**KIRKLEES METROPOLITAN COUNCIL
TOWN AND COUNTRY PLANNING ACT 1990
HIGHWAYS DEVELOPMENT CONTROL KP20H**

PLANNING REF 2016/62/91573/W0/FT
CATEGORY Small Major

PROPOSAL DEMOLITION OF EXISTING
REDUNDANT MILL BUILDINGS AND
ERECTION OF 55 DWELLINGS
WITH ASSOCIATED PARKING AND
ACCESS FROM MANCHESTER
ROAD *SHLAA REF 709*

LOCATION CELLARS CLOUGH MILL,
MANCHESTER ROAD,
MARSDEN,
HUDDERSFIELD,
HD7 6LY

Proposed Access

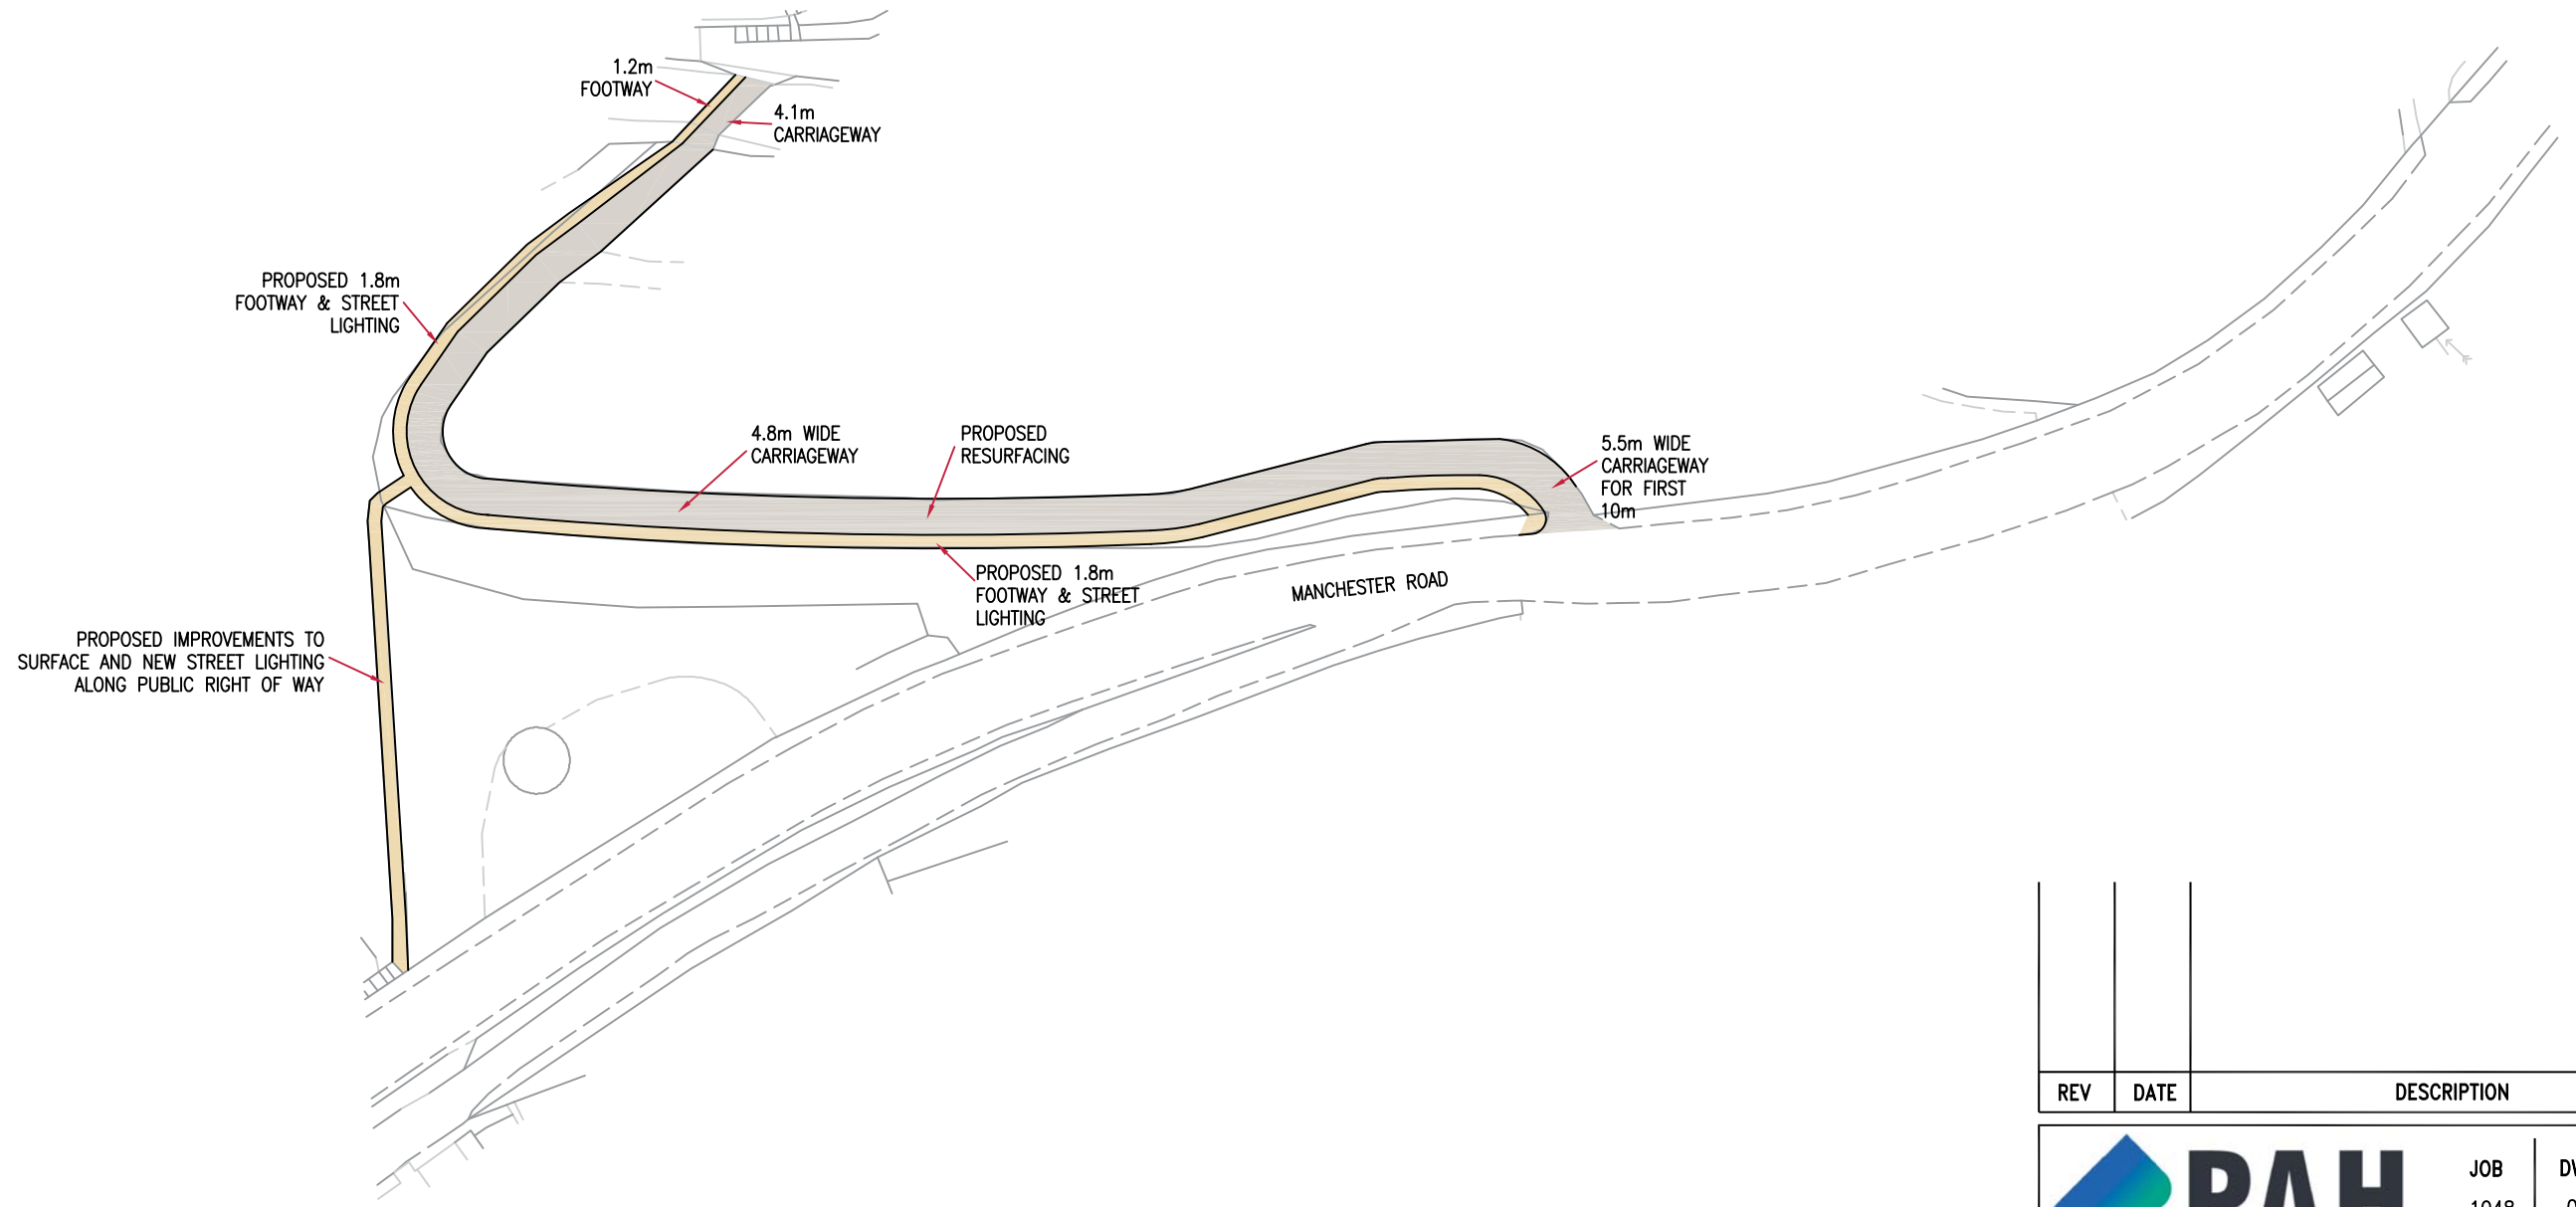
The improvements proposed by the previous approval including the widening of Manchester Road to create a right turn lane with the provision of a pedestrian refuge are still considered necessary.

The proposed improvements to the access road included in the previous application are also considered necessary with increased widening at the access and to the severe bend in the access road. Ideally the carriageway width should be 5.5 metres in width with a 2.0 metre wide footway and 0.6 metre hard margin. Vehicle restraint will need to be shown to be provided along the length of the access road.

The proposed sight lines onto Manchester Road are based on a 2007 survey. These need to be based on up to date speed survey information. The sight lines should be measured to the carriageway edge and not the centre line given that there is currently no physical separation between the carriageway lanes.
